From: Martyn White
Sent: 31 August 2018 11:22
To: Anita Gardner
Subject: AB/61/18

AB/61/18

The proposal is for replacement windows to the side of the building. The existing windows are constructed from inappropriate materials, and are visible to the public highway.

Side (South) elevation 1:50

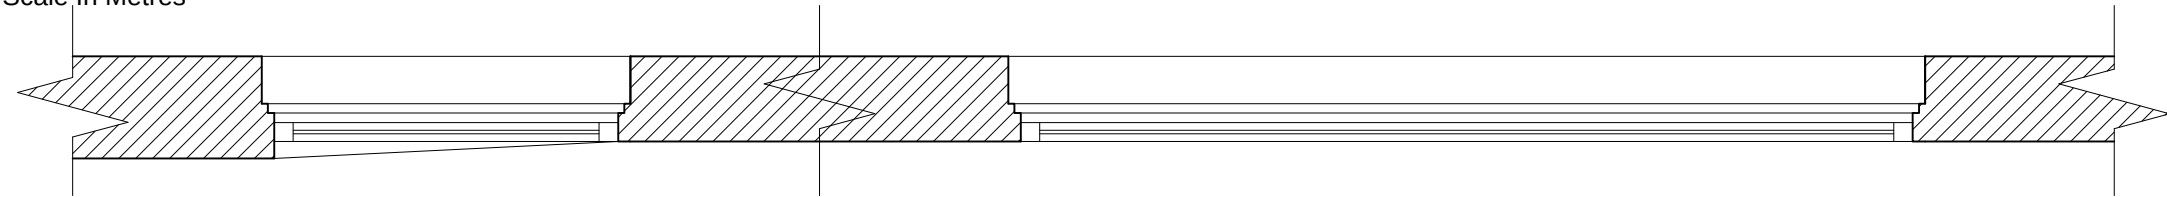
The revised details, which have recently been provided, ensure that all of the proposed windows are multi-paned. Such an approach is supported as the proposed windows now bear some resemblance to those that were previously removed. As a consequence, the application can now be supported.
